28 January 2018

Alexandria Park Community School Redevelopment, Park Road, Alexandria (SSD 8373) submission

3 WINTER 3PM
1 : 1000

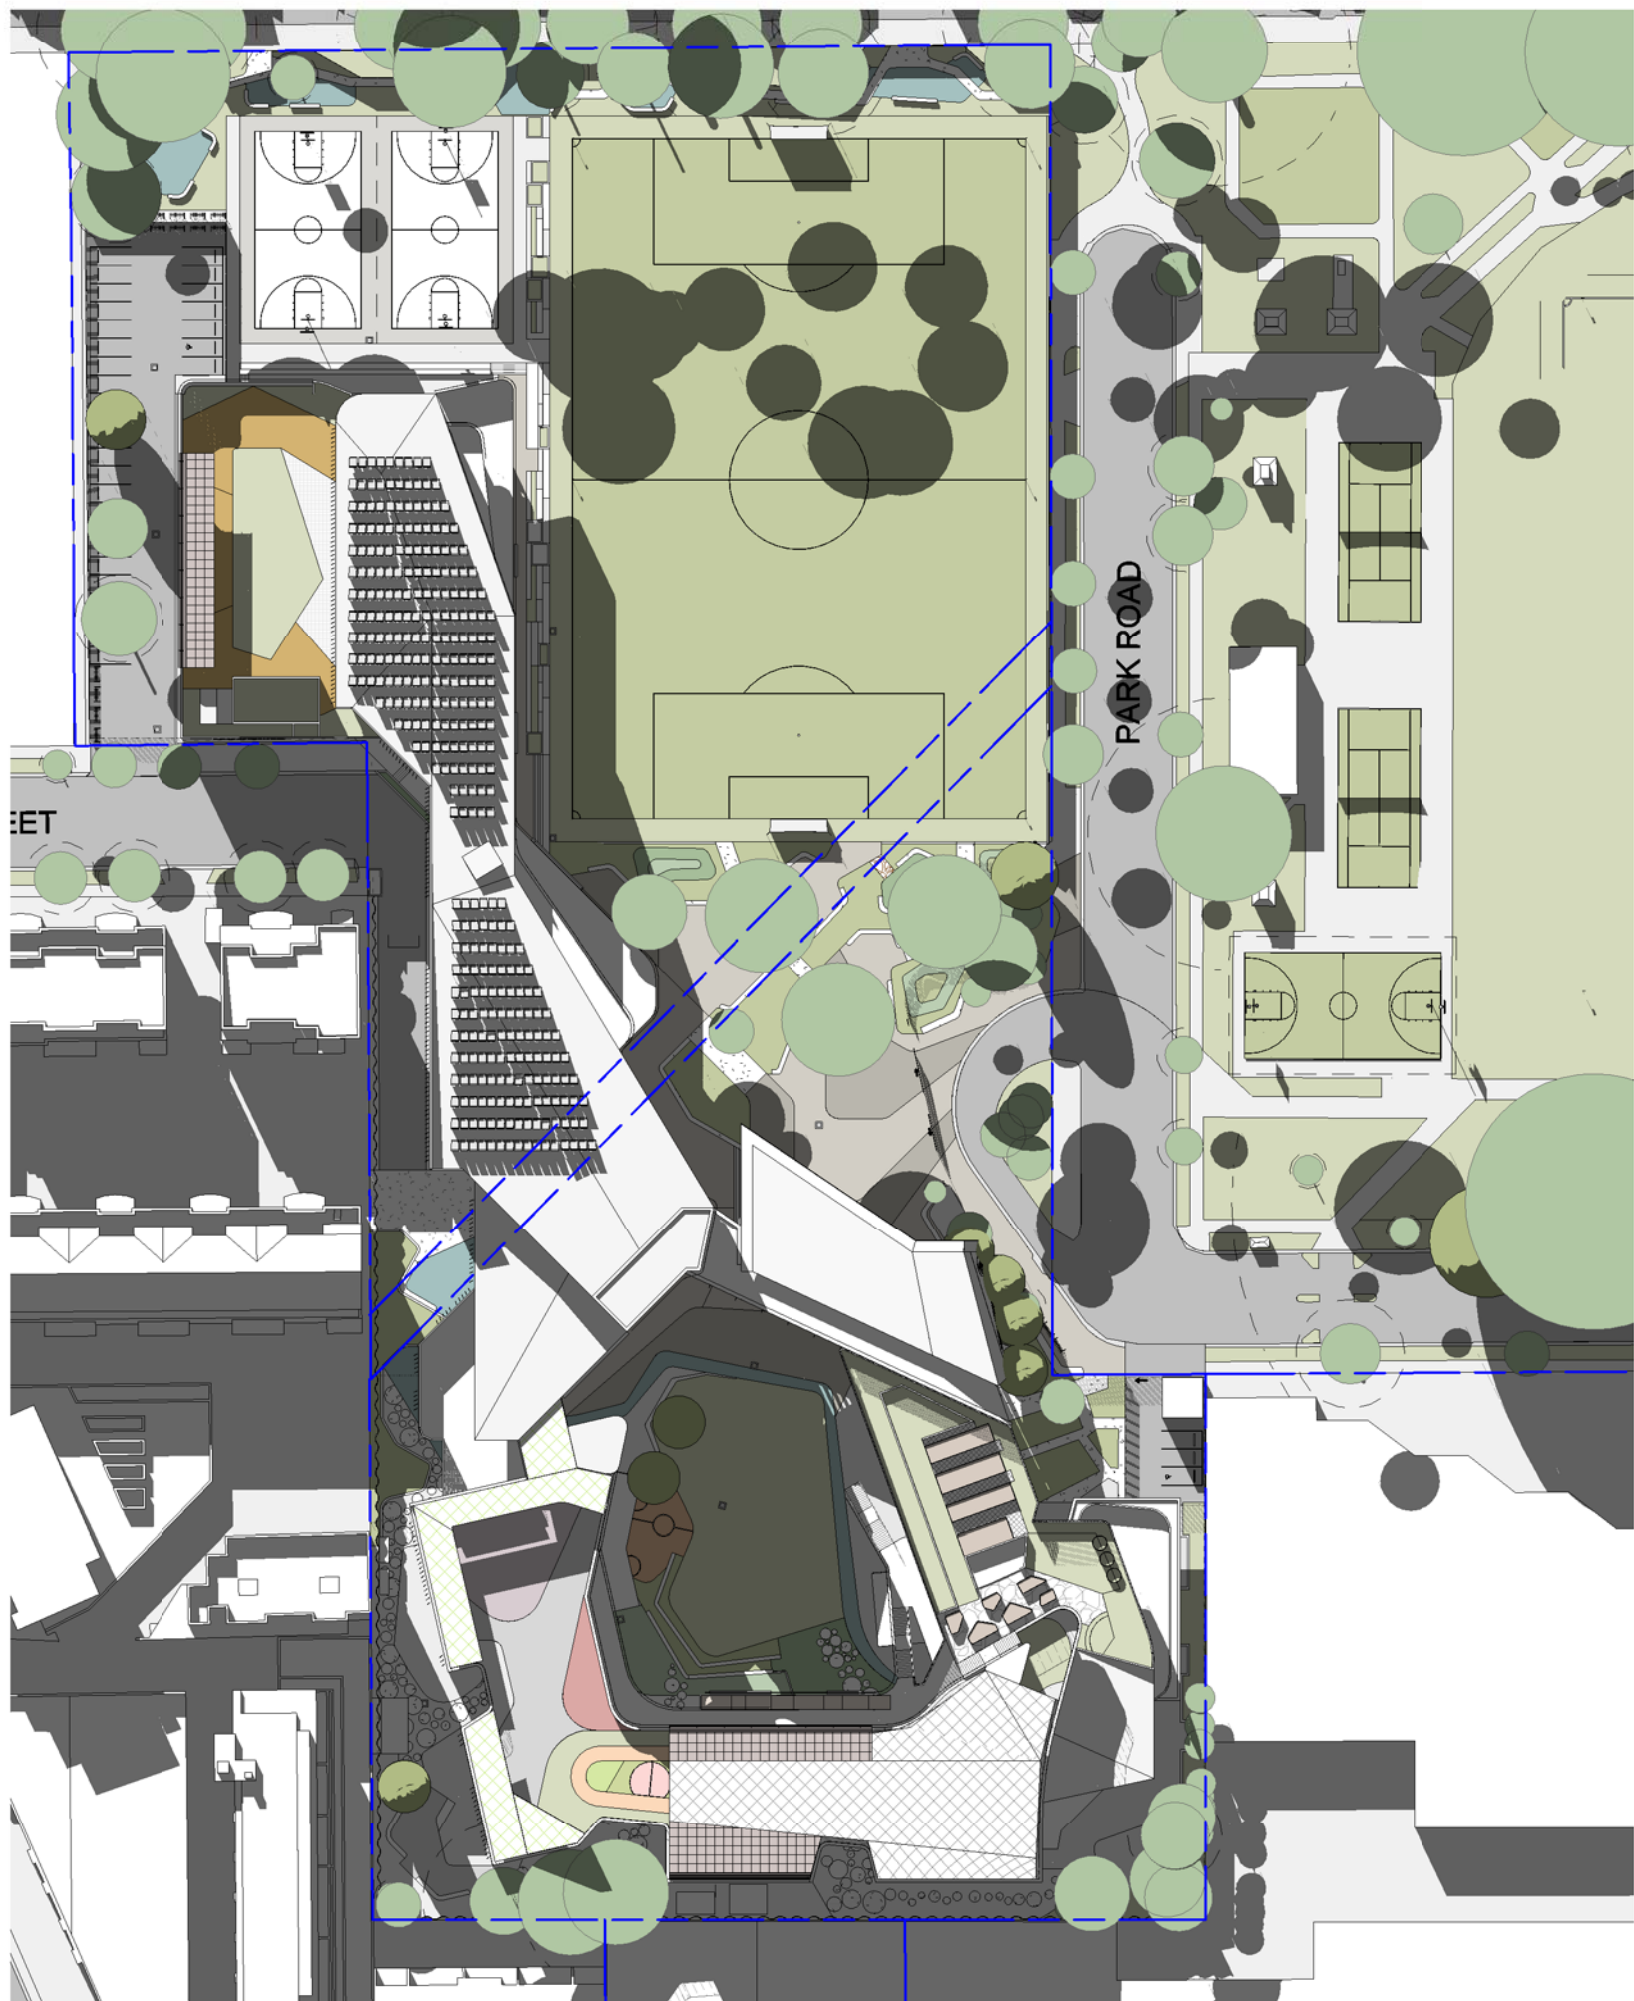
We are extremely concerned at the solar overshadowing the proposed 5 storey, 21 metre building will cause to our ground floor garden apartment Lot 10 of 44-58 Belmont Street, on the Western side of the school. From the shadow diagrams provided, our primary living area, dining room kitchen and front garden courtyard will lose approximately 50% or 4 hours of full sun light on the winter equinox from sunrise at 7.00am until approximately 11.00am. Our apartment again will lose sun due to overshadowing by existing buildings to the north of our apartment sometime mid afternoon. It is unclear how many hours of direct solar access we will have left if the proposed school building is built. Due to the design of our apartment, having only two points of solar access, a front sliding door facing north and a back door facing south, with no other windows on either the east or west of the apartment, we are heavily reliant on good solar access for light and warmth and wellbeing from these points. If hourly solar overshadowing diagrams could be provided as required they would assist to clarify the extent of overshadowing.

We respectfully suggest that consideration be given to exploring opportunities to reduce the extent of solar overshadowing on neighbouring residences on the western boundary of the school. A combination of the following may be considered:

- Reducing the height of buildings which will overshadow neighbours on the western boundary to the current 15 m height limit for this site;
- Terracing the western facing upper floors back from the western boundary; and/or
- Moving buildings on the western boundary further away from neighbouring residences.
